**ADC Planning Consultation
Response from the Historic Buildings Adviser**

Application Number	AB/8/12
Address	Land adjacent to 84 Maltravers Street, Arundel
Description	Erection of 1 new dwelling.
Case Officer	Anita Gardner
Site Visit	29 February 2012

Objection

Elevations & Section

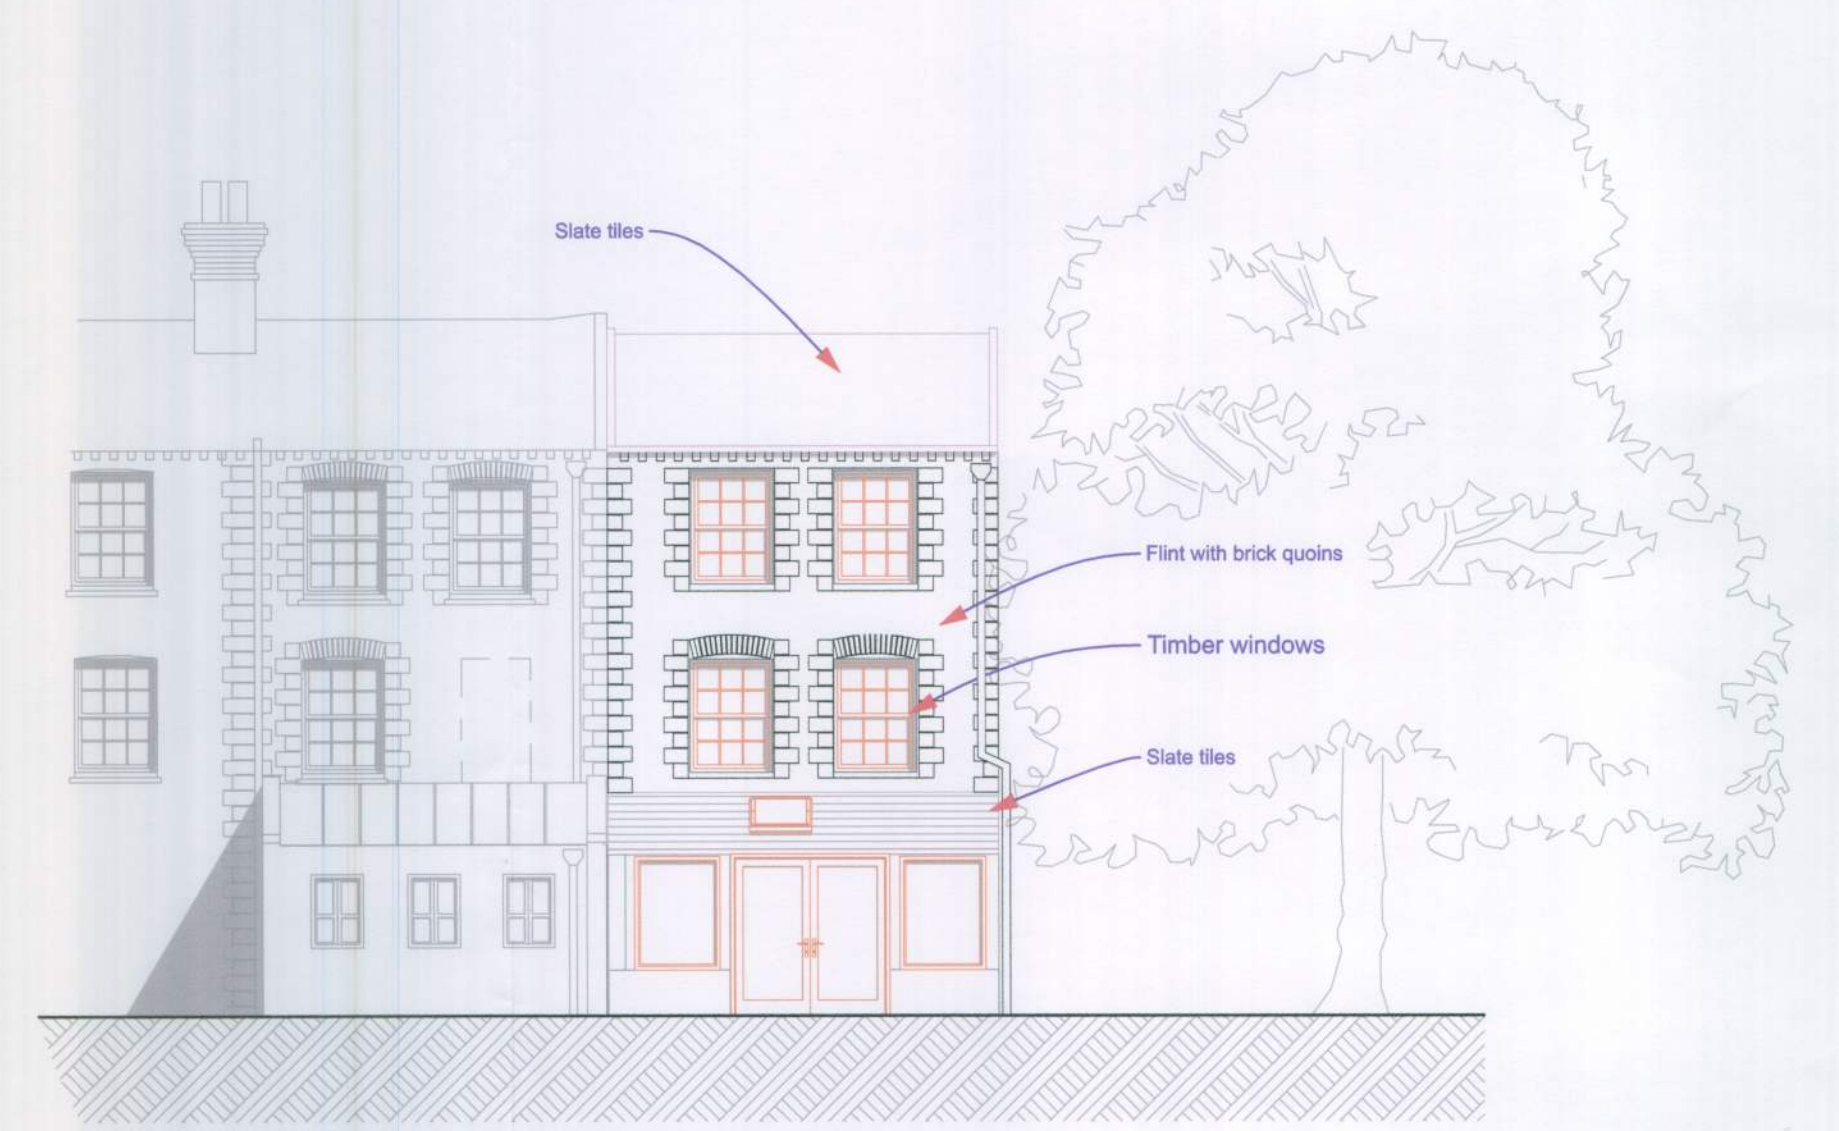
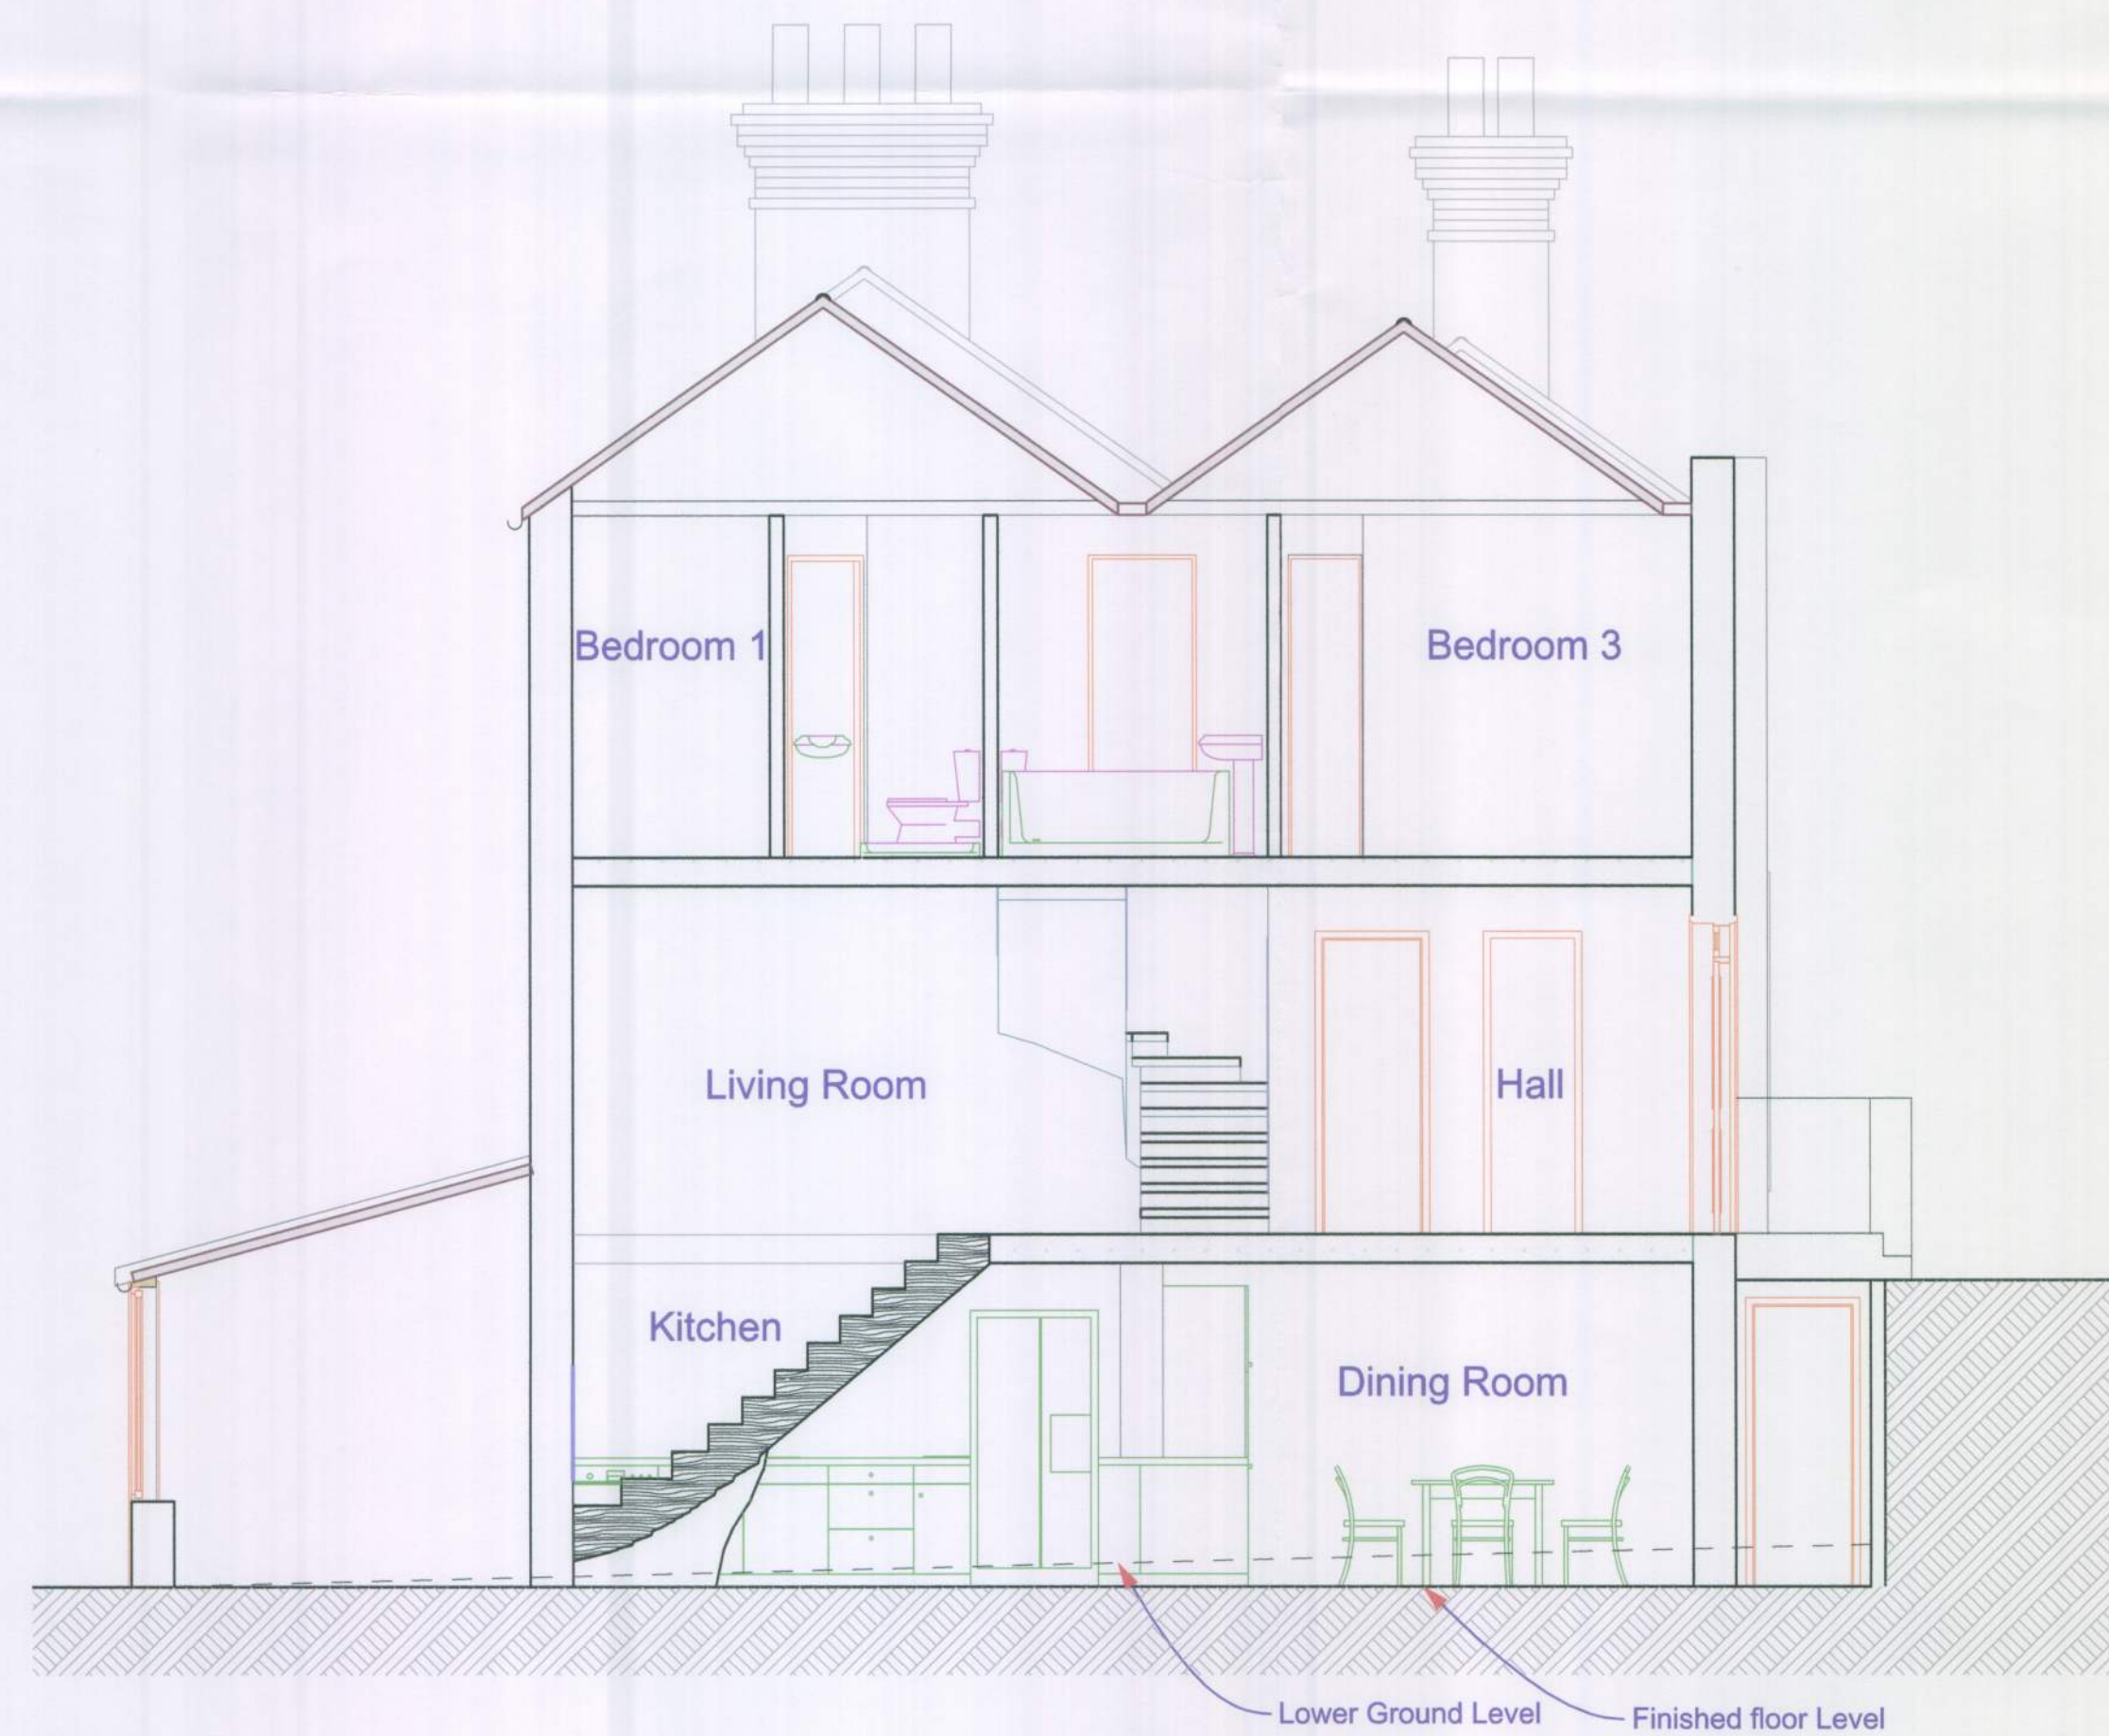
Unfortunately, the proposal to add a further dwelling to the terrace can only compromise its historic form and design and as such its broader contribution to the conservation area as described. It would certainly harm the symmetry of the group as well as undermine its integrity as an historic feature of the town. The variation in the new building's design, such as its set back position, lower ridge level and alternative treatment of the front boundary, only compounds this as it seeks to be sympathetic with the terrace, but ultimately remains alien to it.

This not only impacts directly on the building itself but also its setting which is fundamental to the building's appreciation within the conservation area. Of particular concern here is the space around and either side of the building, its relationship to the street scene, as well as the permeability of the site which contributes to the asset and its broader context. Policy HE10.1 is quite clear about this:
